From: Stuart Corbey
Sent: 18 December 2018 13:28
To: Lynnyrd Wolfe
Subject: FW: 2 Pagham Road, P/99/18/HH
Attachments: 2 Pagham Road - Proposed Elevations and Street Scene - P003_C.pdf; 2 Pagham Road - Proposed Sections - P006_C.PDF

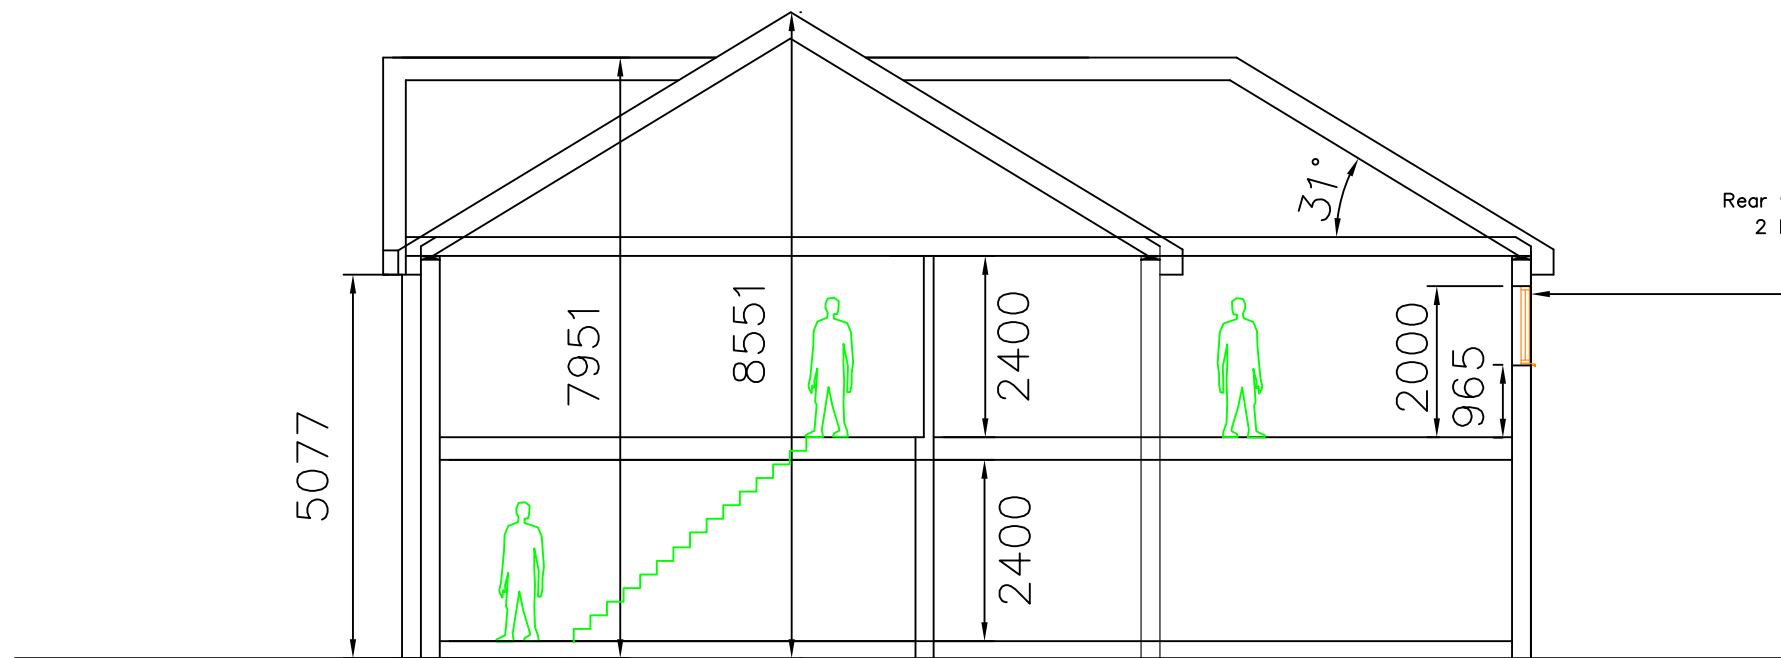
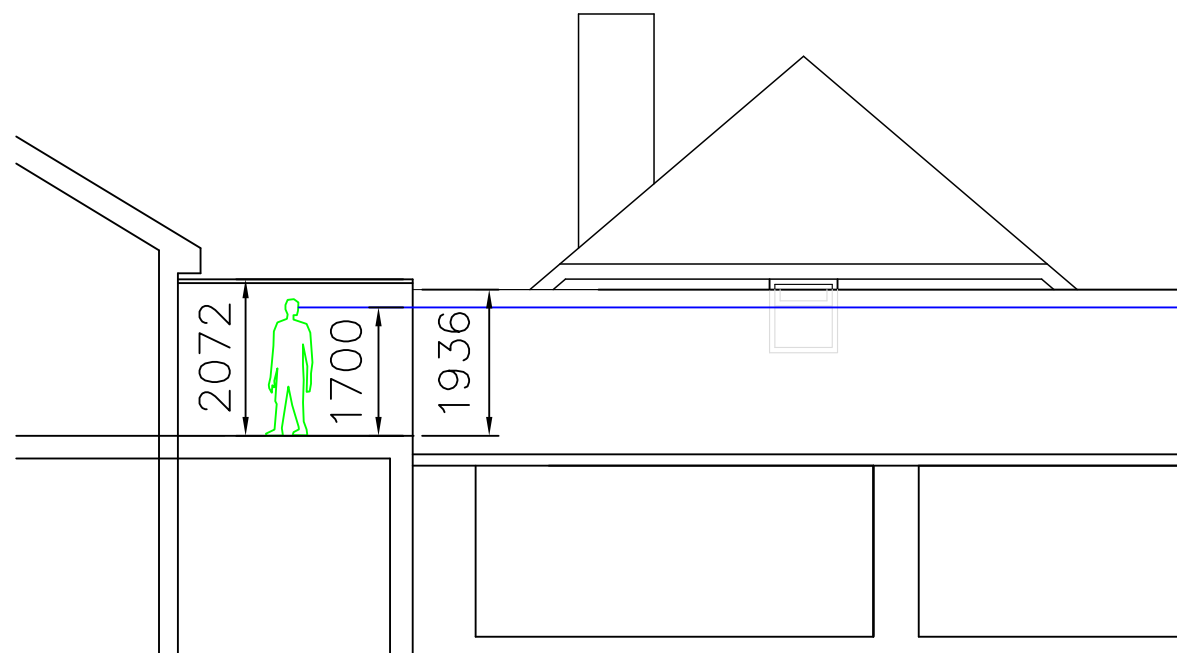
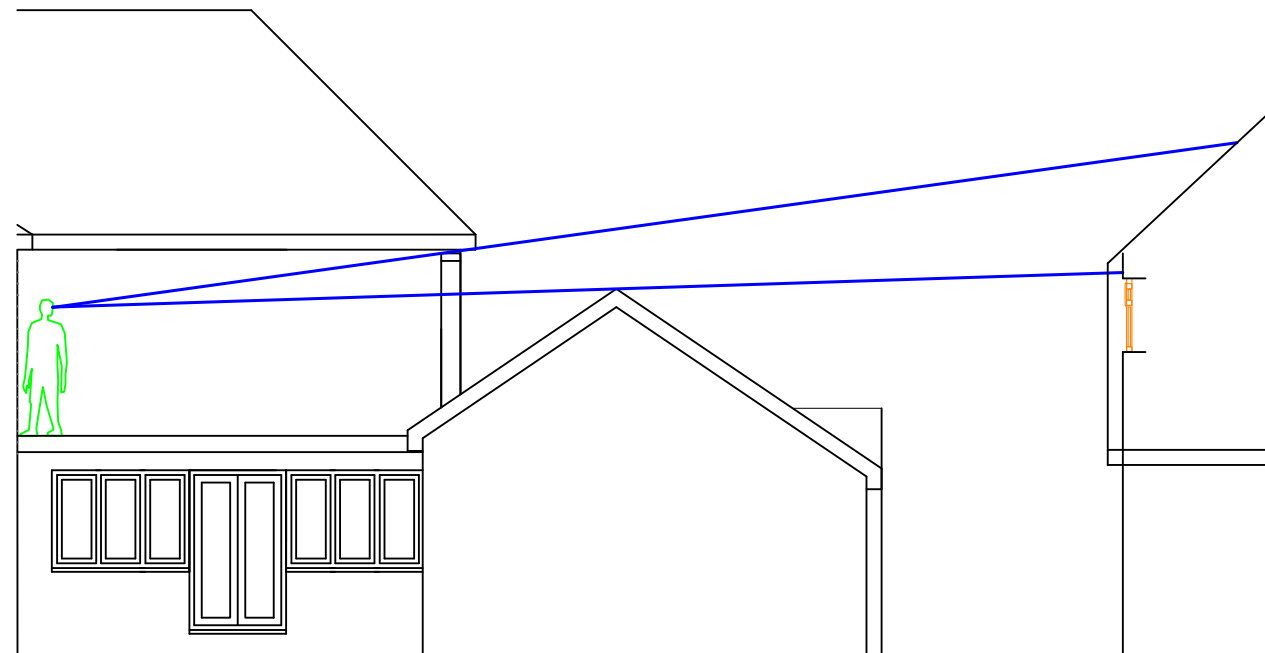
What would be helpful is a cross section and elevation of the proposed development inclusive of the site arrangement with the existing outbuilding (dotted line) in addition to extant permission under P/18/03. This level of plan would make the situation more clear and assist with the assessment.

I am not sure what more detail I can provide to the cross-section P006_B so please could you give me a call to explain what exactly you require, and I will get this done immediately. I have left you a voicemail also this morning.
